CITY OF ALBUQUERQUE

November 20, 2018

Re: Family Dollar
1400 Gibson Blvd SE
Request for Certificate of Occupancy
Transportation Development Final Inspection
Engineer's/Architect's Stamp dated 02-12-18 (L15D049)
Certification dated 11-19-18

SHEET NUMBER
TCL-1.0

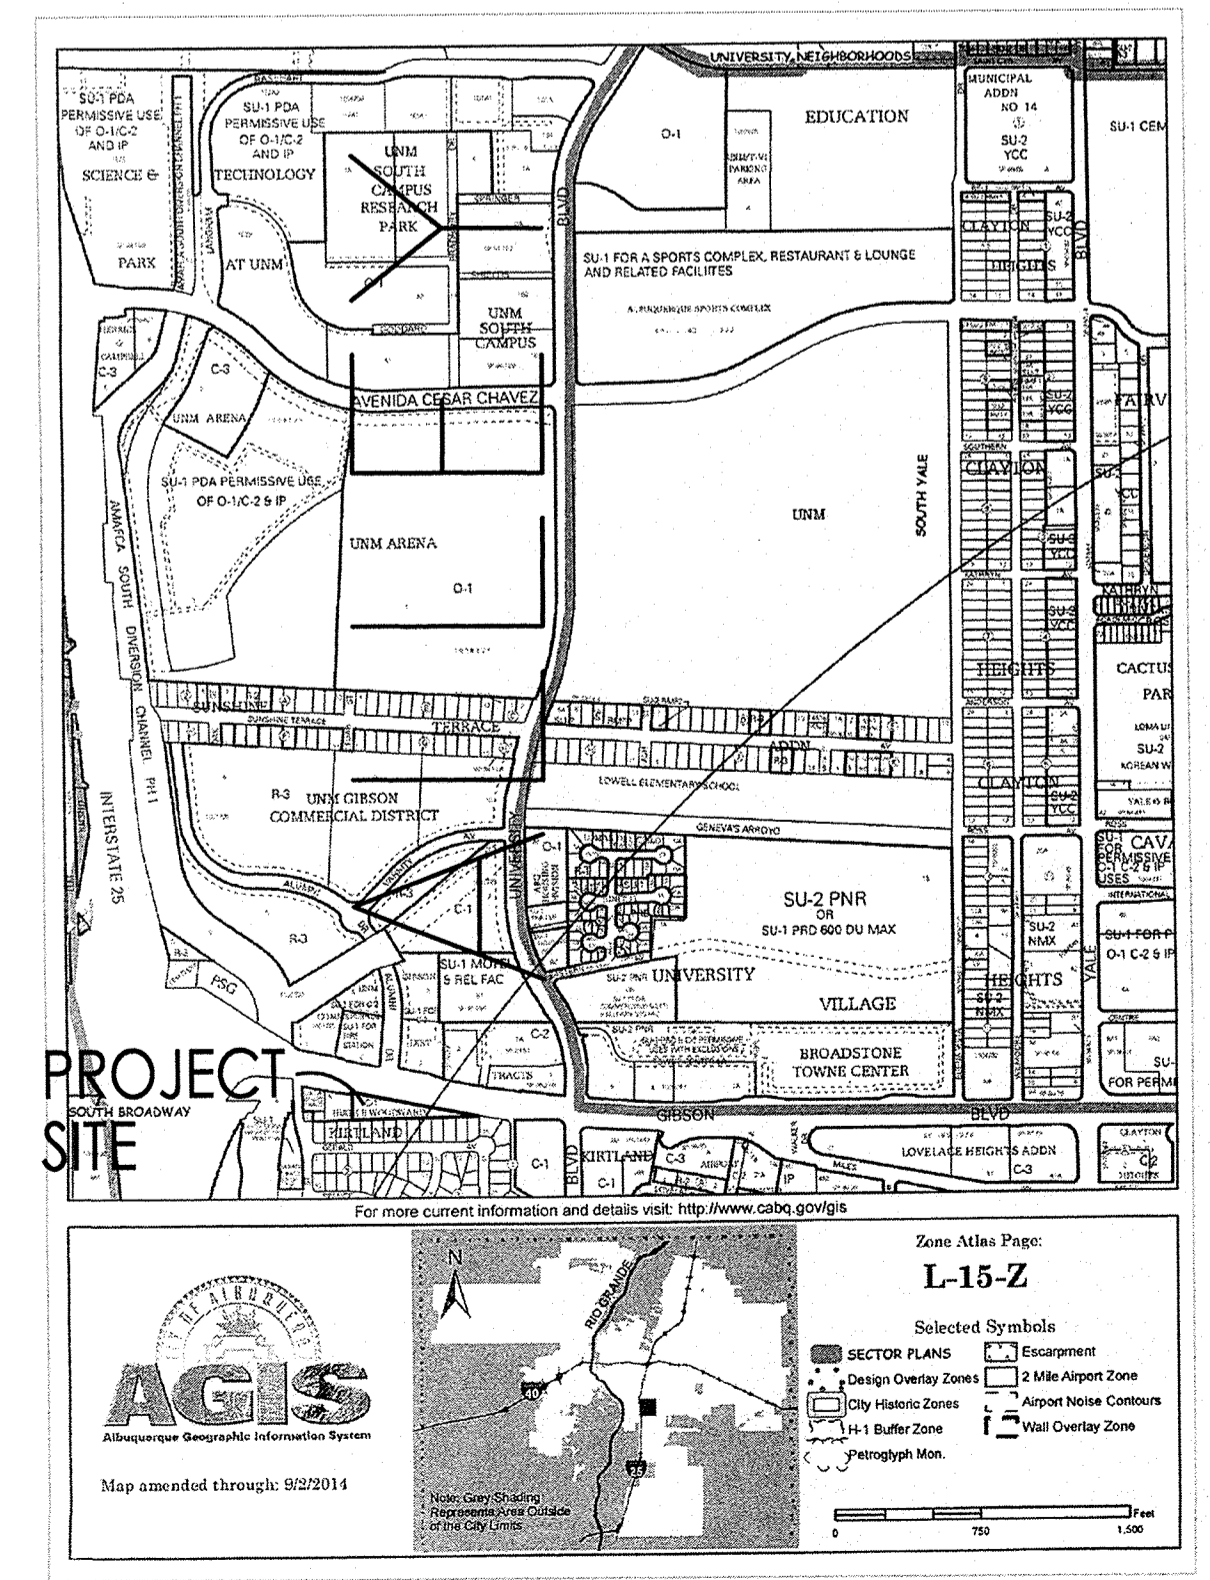
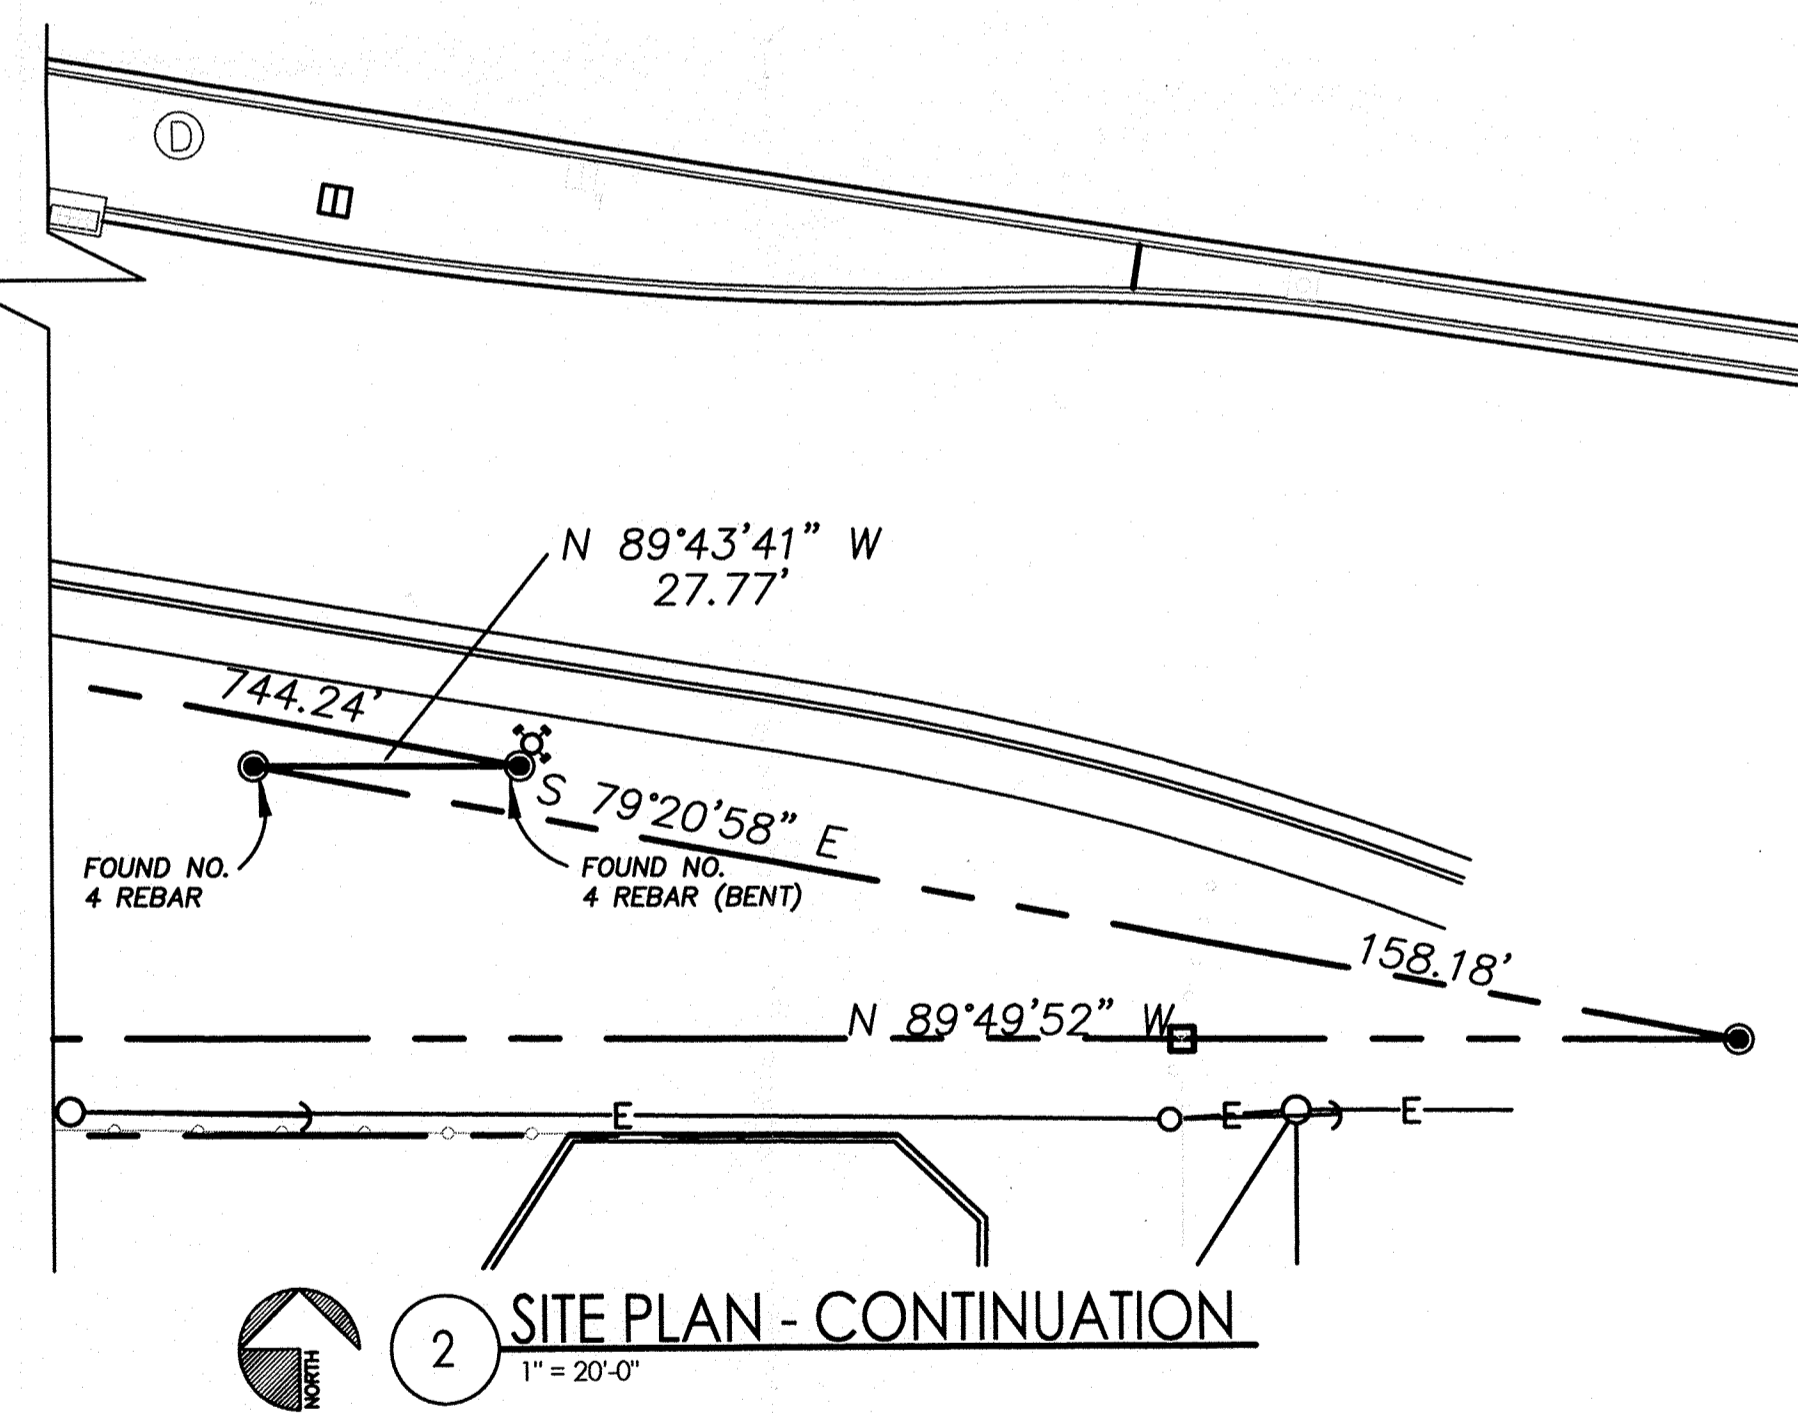
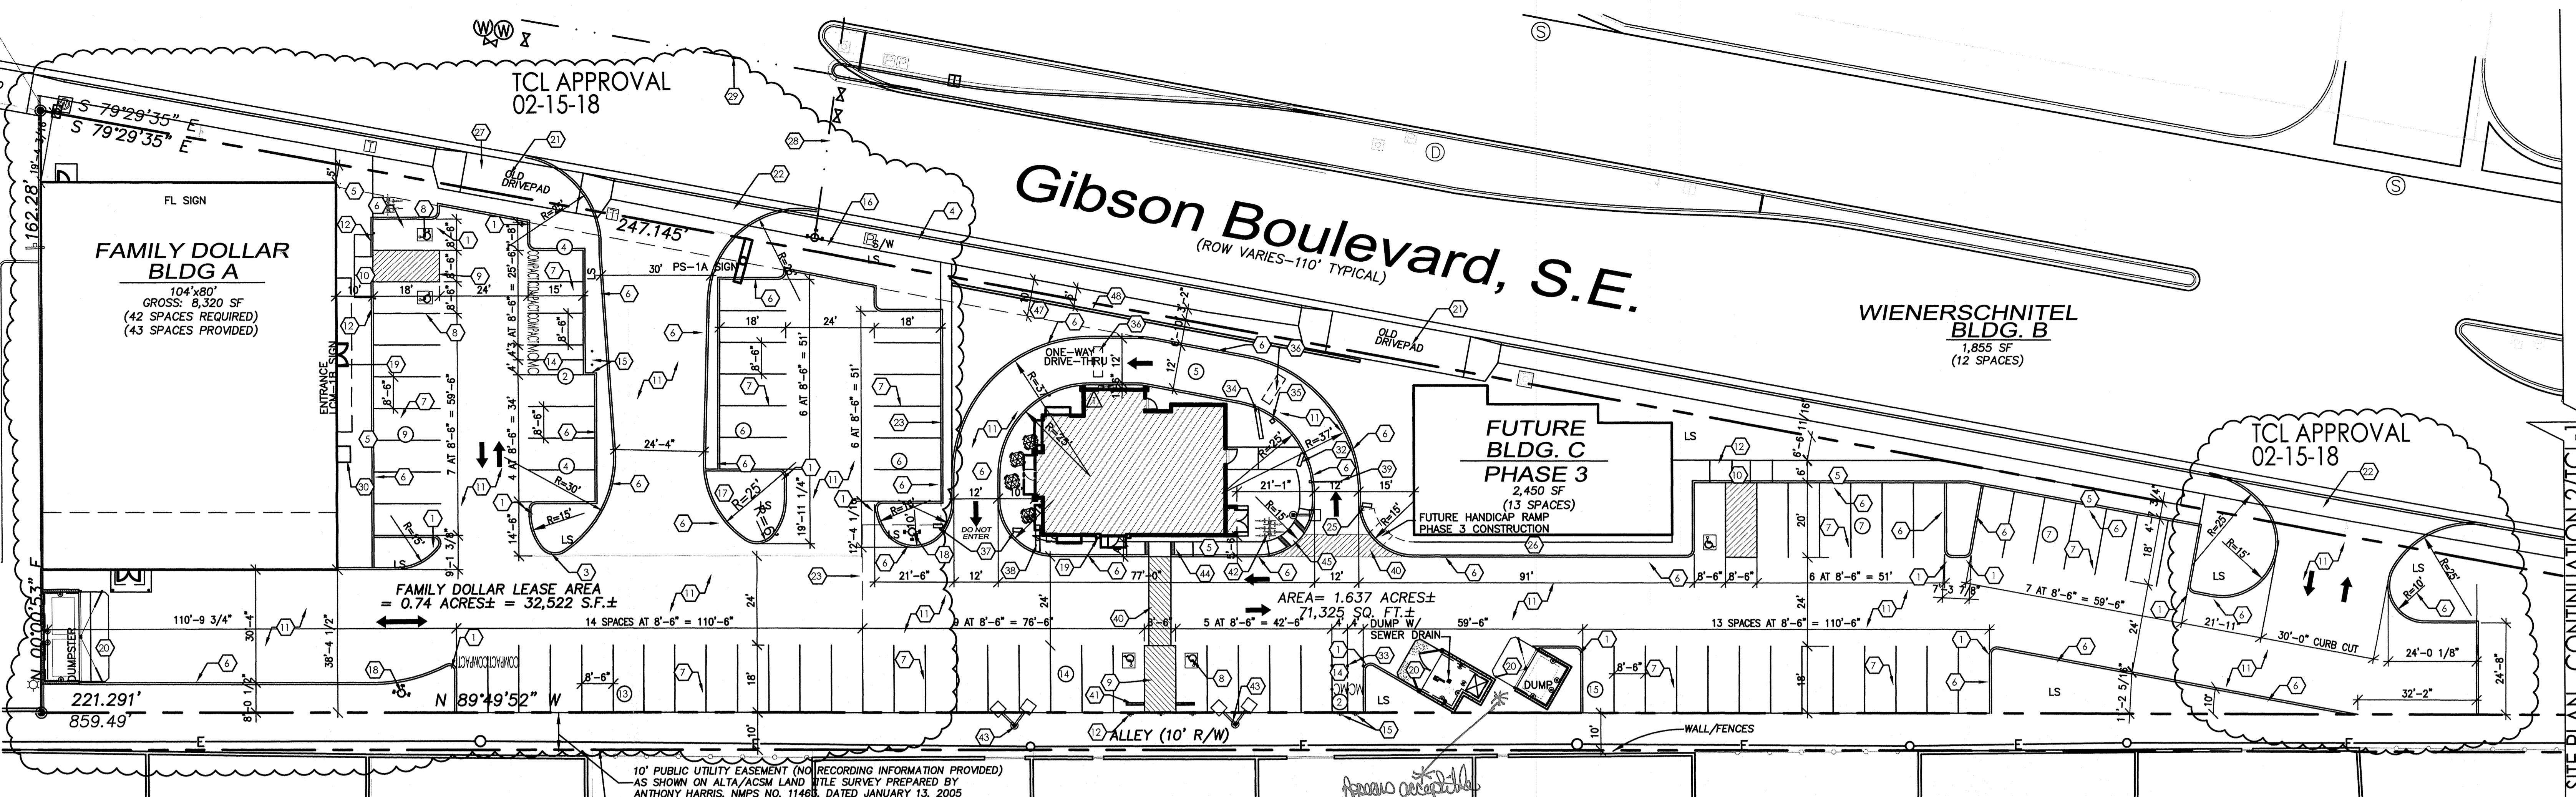
1. Close out of work order.
2. Paint "No Parking" in access aisle.
3. Add Bike parking.
4. When resubmitting for final please attach the approved revised TCL plan dated 5-10-18
